PROPOSED SOUTH ELEVATION
1: 100 @ A1

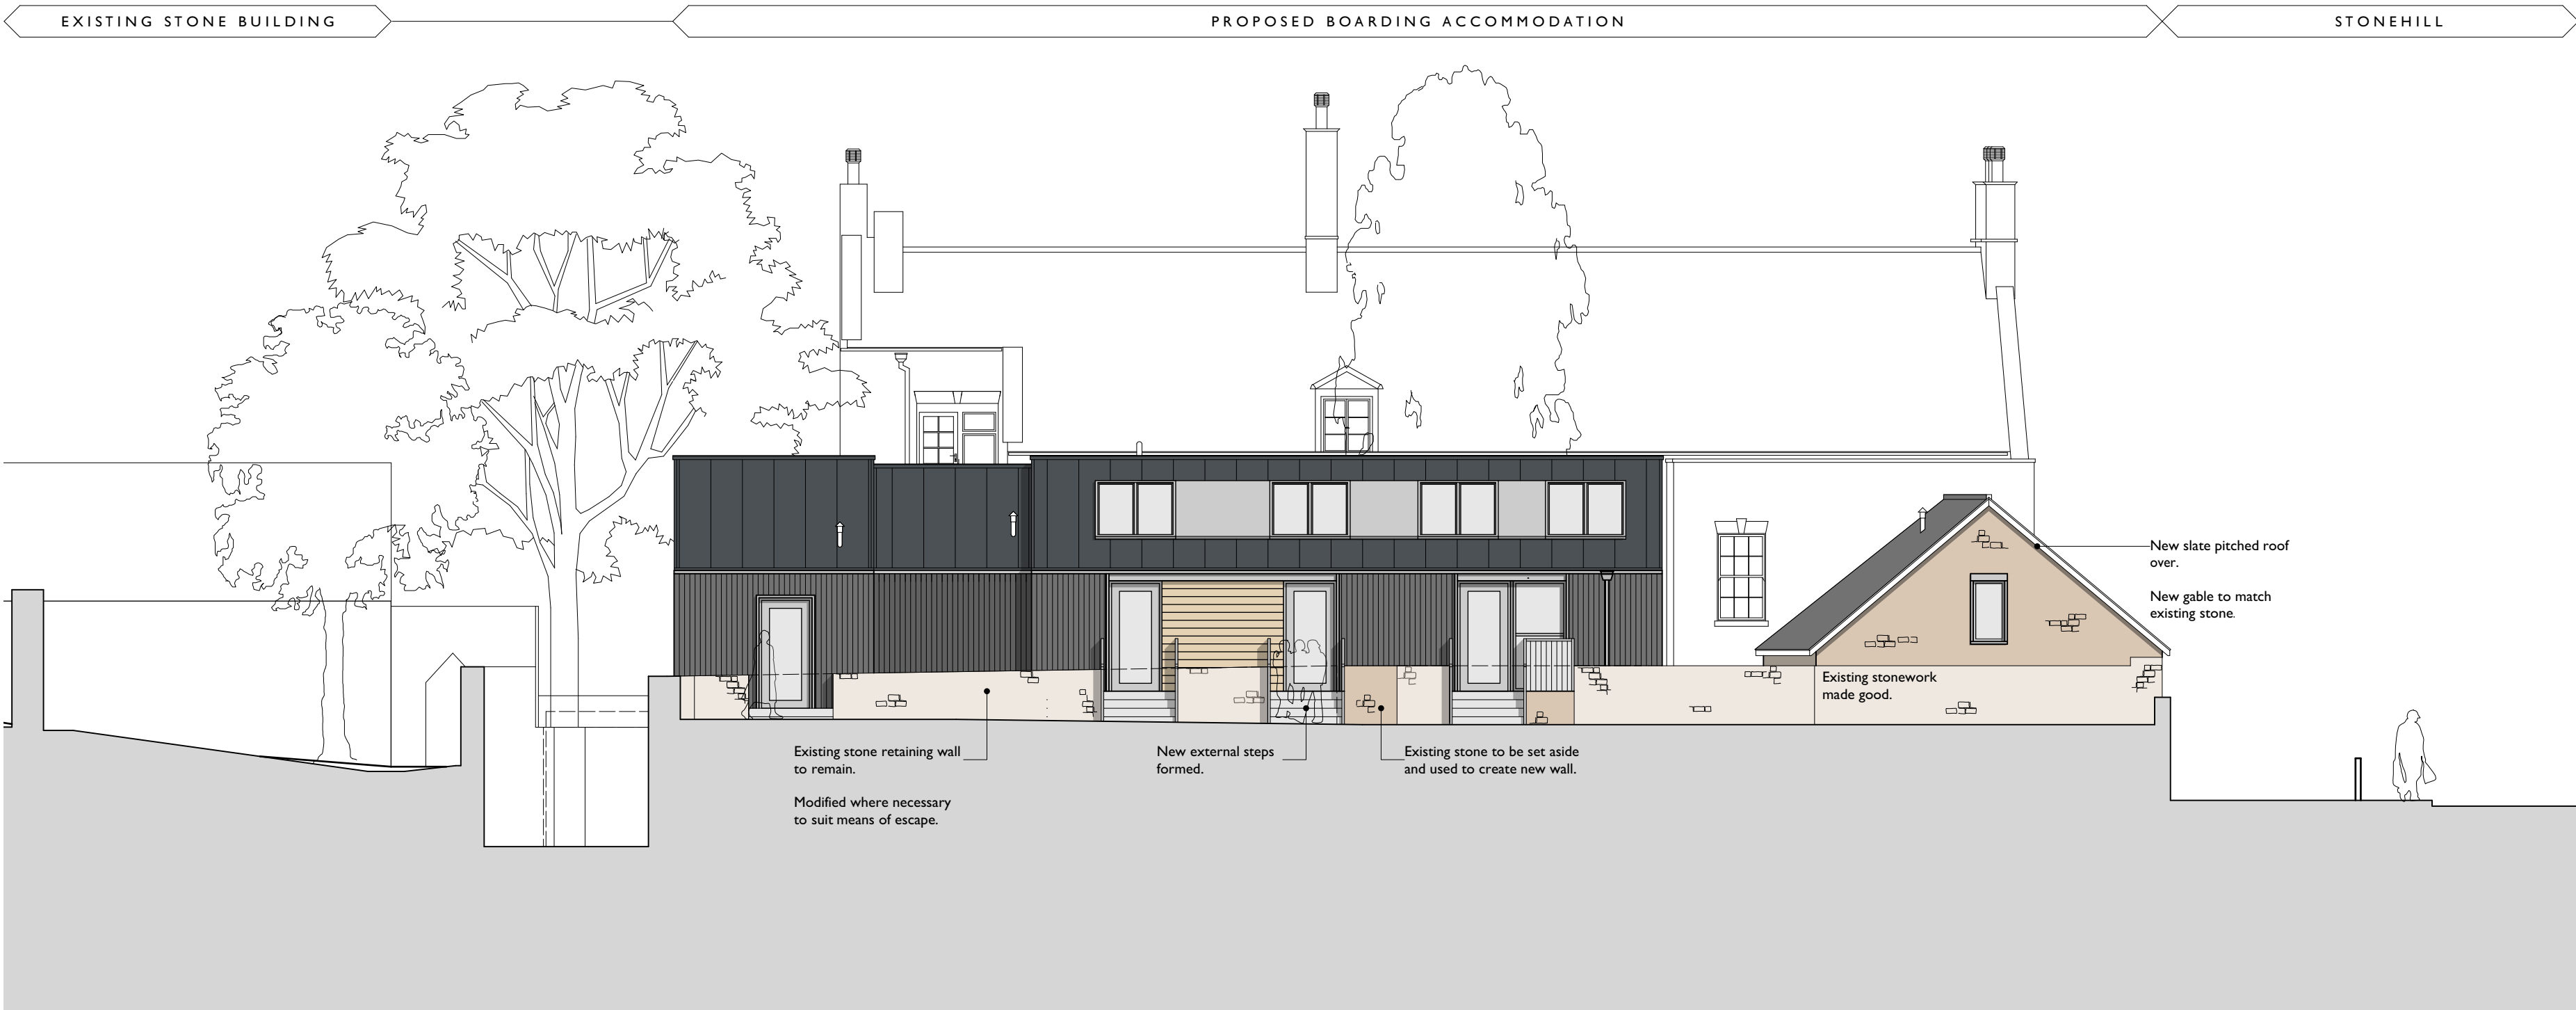
I have just spotted that on August 26th, 2021, HCUK Group for Bloxham School sent a revised South Elevation for the above application. The change of material from zinc to slate is a poor attempt to make the building more sympathetic which it will not achieve. The whole project is still :

- much too big for the size of the street.
- will not blend with the surroundings and enhance the Conservation Area
- will make the beautiful arch of the Old Coach House which is the most important feature of this street completely insignificant
